RE: Planning Application AB/115/14/OUT

I am writing to object to the outline application for 2 semi-detached houses to be built in the front gardens of 12 and 14 Canada Road, Arundel. I am an immediate neighbour and I am very concerned that the proposed development will have an unacceptable adverse impact for owners of the adjoining properties.

Drg Title: SITE PLAN		Drg No: 14/1950/S01
Client:	Location:	Rev: A
MR SCODFREY	12-14 CANADA ROAD	Scale: 1:200 (A3)
	ARUNDEL	Drawn by: JSW

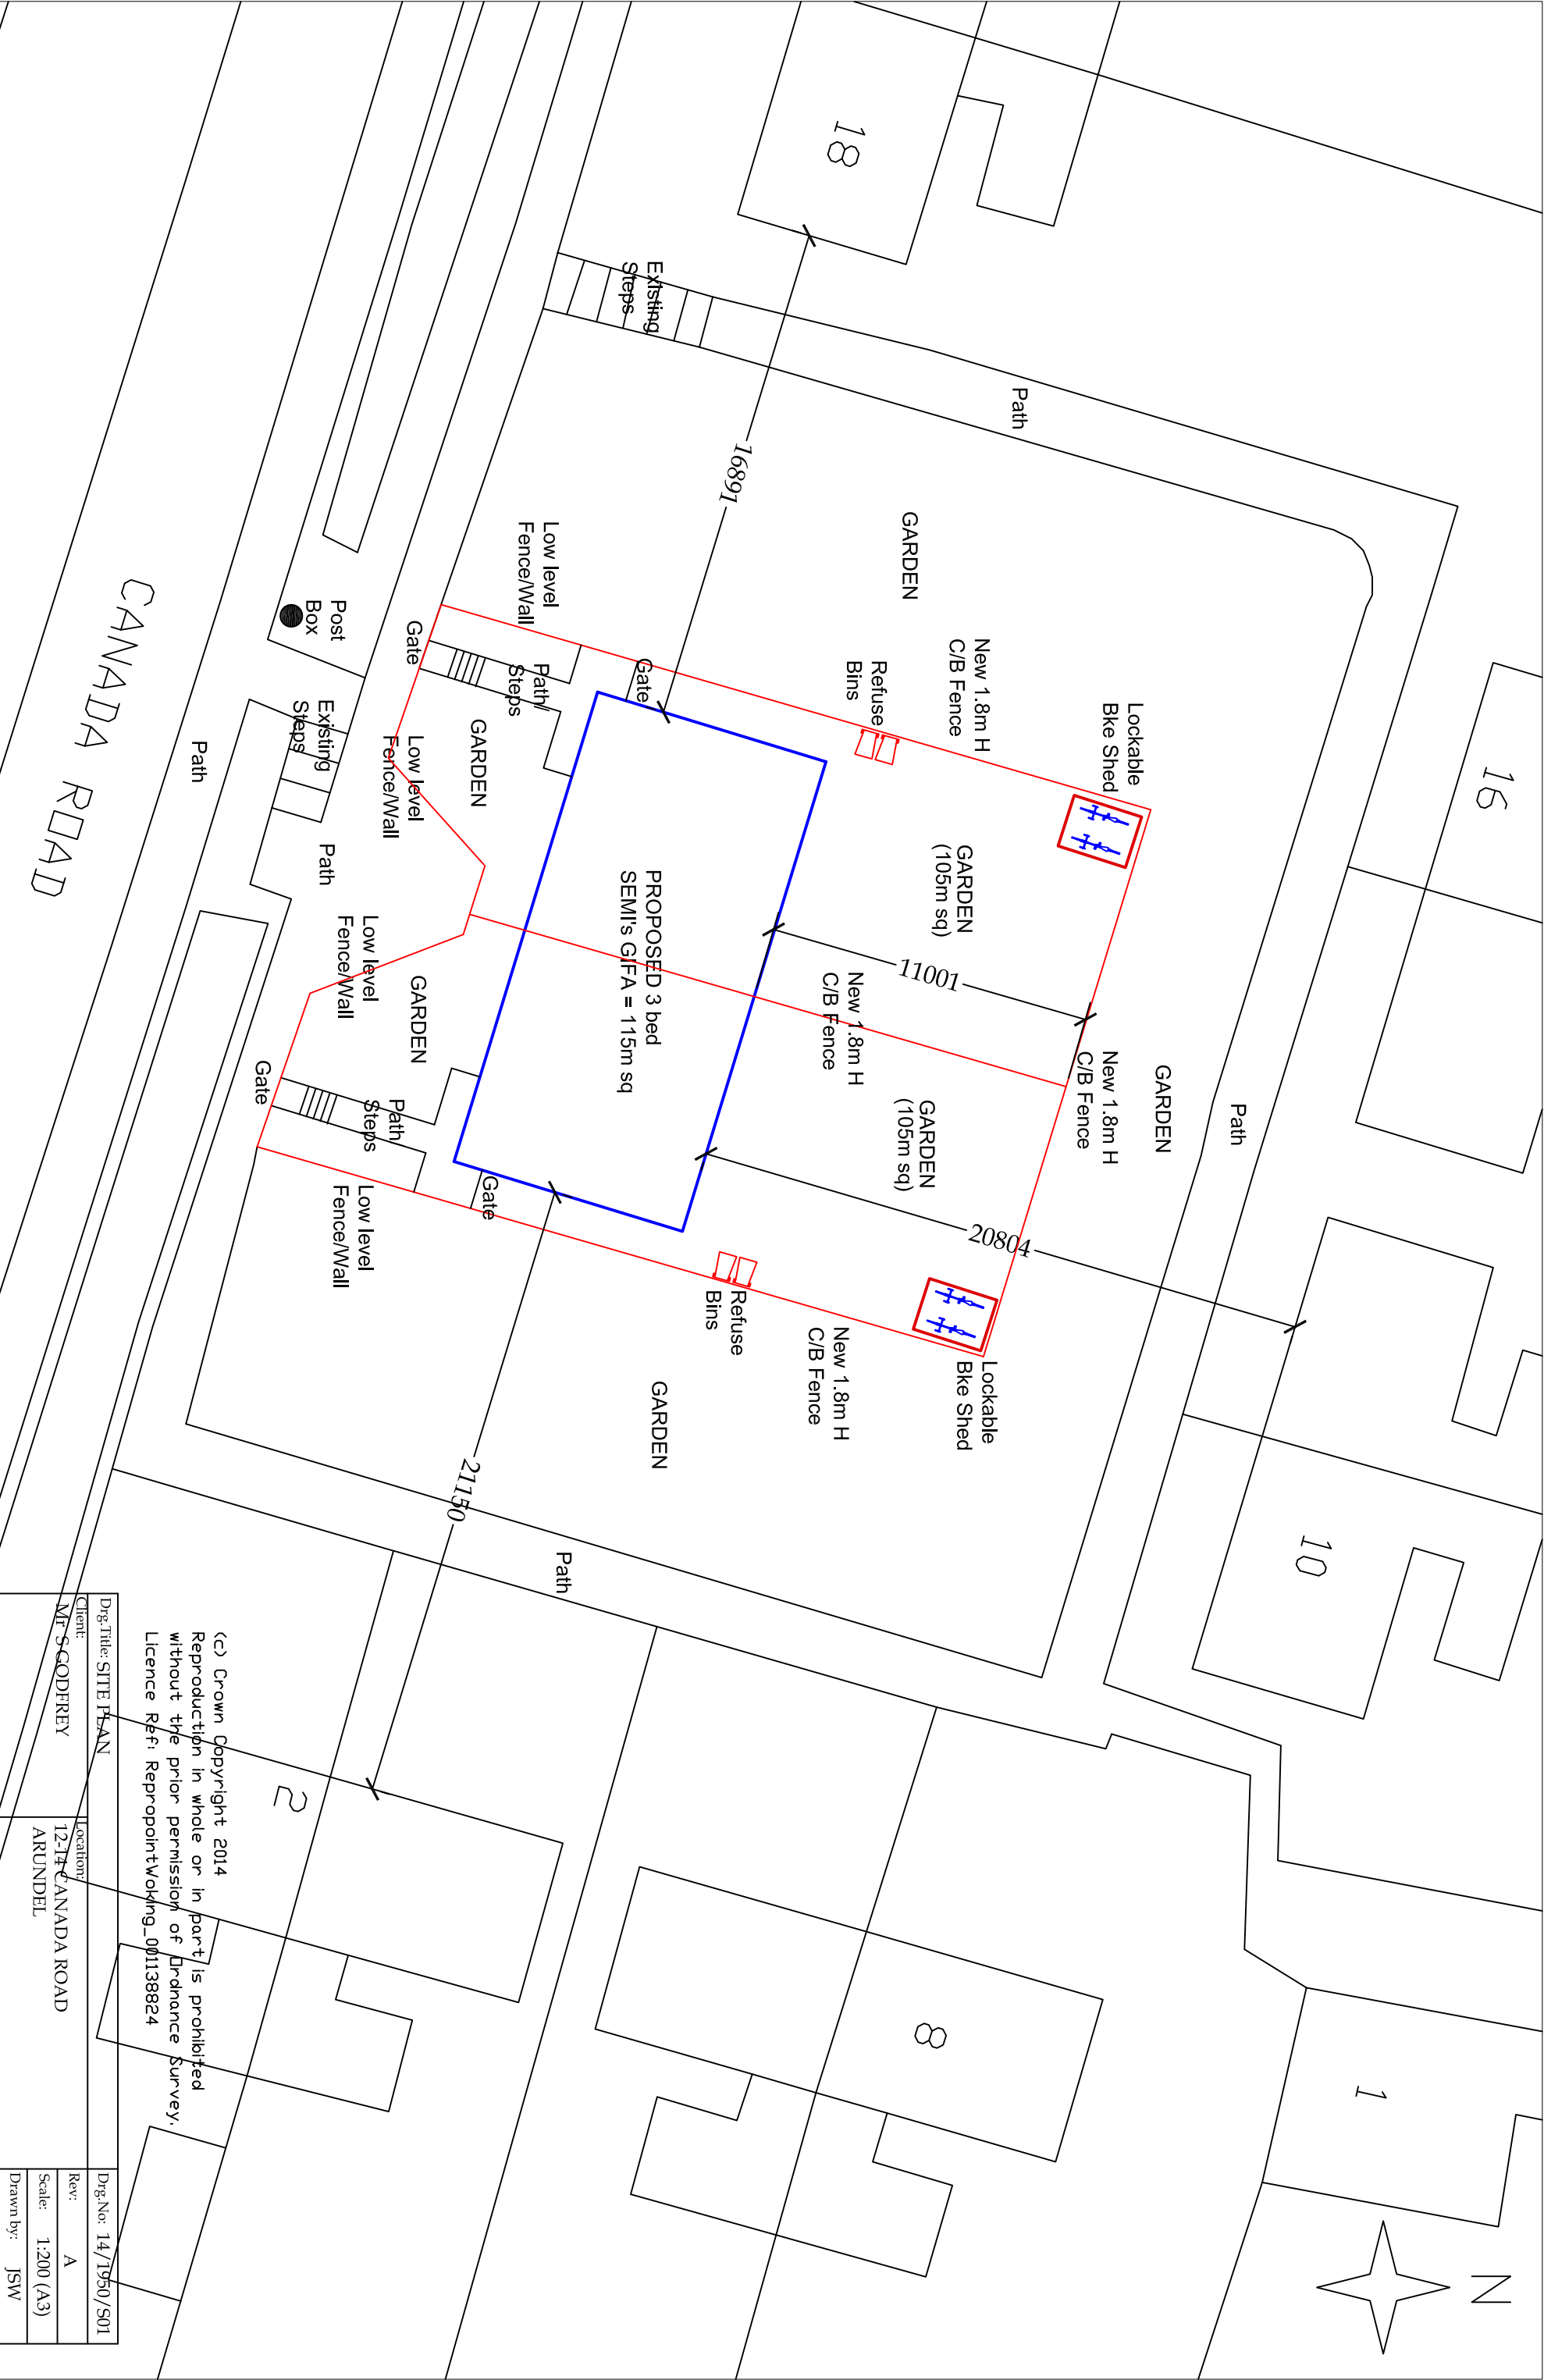
Overlooking windows (even with the measures to reduce this that are listed in the application), loss of open plan leading to an increased sense of enclosure due to the size, orientation and position of the proposed development in relation to existing properties, loss of light and vehicle parking issues.

The properties 10 to 16 Canada Road are characterised by long, open plan front gardens sweeping down to the footpath. Properties 2 to 8 face onto these front gardens. The proposed development would destroy the open plan and leave the existing properties facing back gardens, being able to see into the new houses rear or side windows and gardens and would result in an unduly cramped form of development which would not be in keeping with the character and amenities of the surrounding area.

On the plan, the proposed houses appear larger, particularly the width, than the existing houses and this design would be out of keeping with the surrounding properties.

I am concerned that the proposed development removes the centre path and makes no provision for access to number 12 and 14 should the residents of number 10 and 16 block the path between the respective houses. This could lead to unwelcomed disputes in the future unless access rights are firmly established as part of this application.
